Date: 7/28/2011 6:54 pm
Subject: Casino - MOD 7
Attachments: Signed submission - amended MUEF - MOD 7.pdf; City's submission - Multi-Use Entertainment Facility _MUEF_ - Star City Casino - MP 08_0098 MOD 7.pdf

The City does however maintain its concerns about loading operations associated with the MUEF and its potential impacts on Sydney Buses and surrounding streets. The potential impacts on bus operations also extends to private coaches that use this route. I understand from Kate that the casino has indicated that there is an agreement or the like between them and Sydney Buses but that this has not been provided to the Department (or Council).

Turning Paths
19m Articulated Vehicle Unloading
12.5m Bus passing

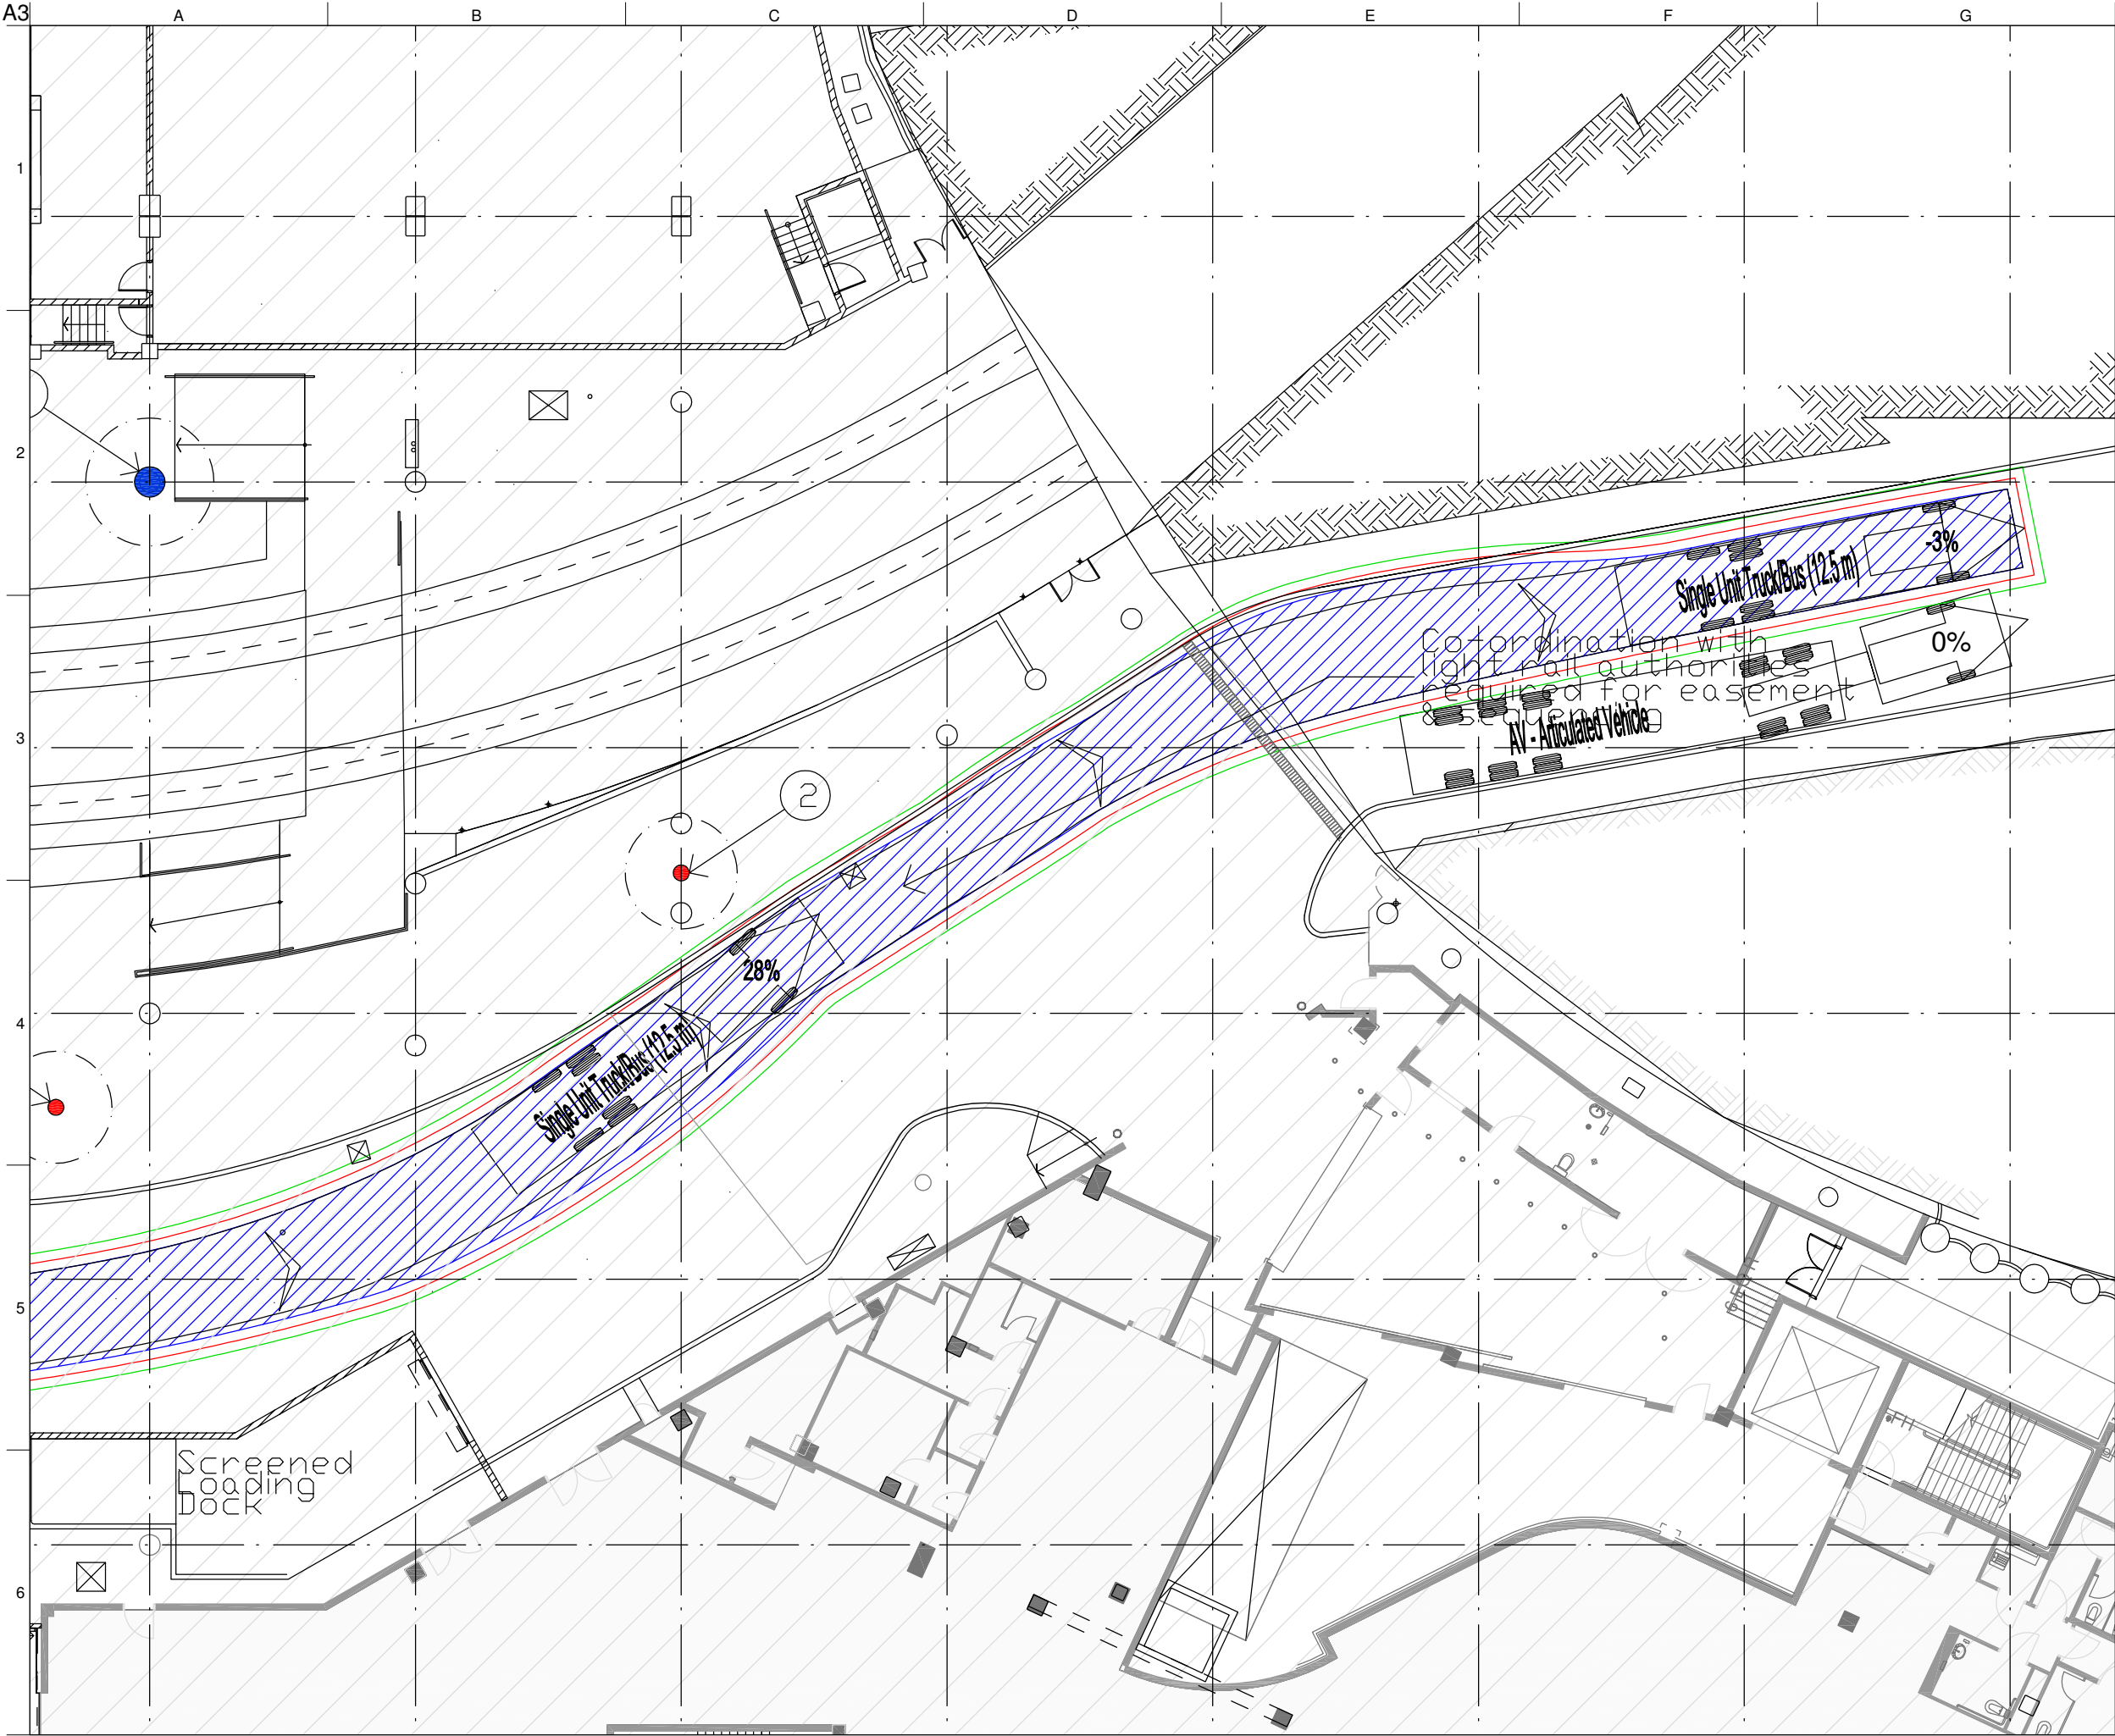
While diagrams show that buses could physically manoeuvre past 19m trucks standing in the nominated location, there is virtually no room for tolerances. The precision demanded of truck drivers to stand in the correct location and for bus drivers to get past doesn't leave much room for error.
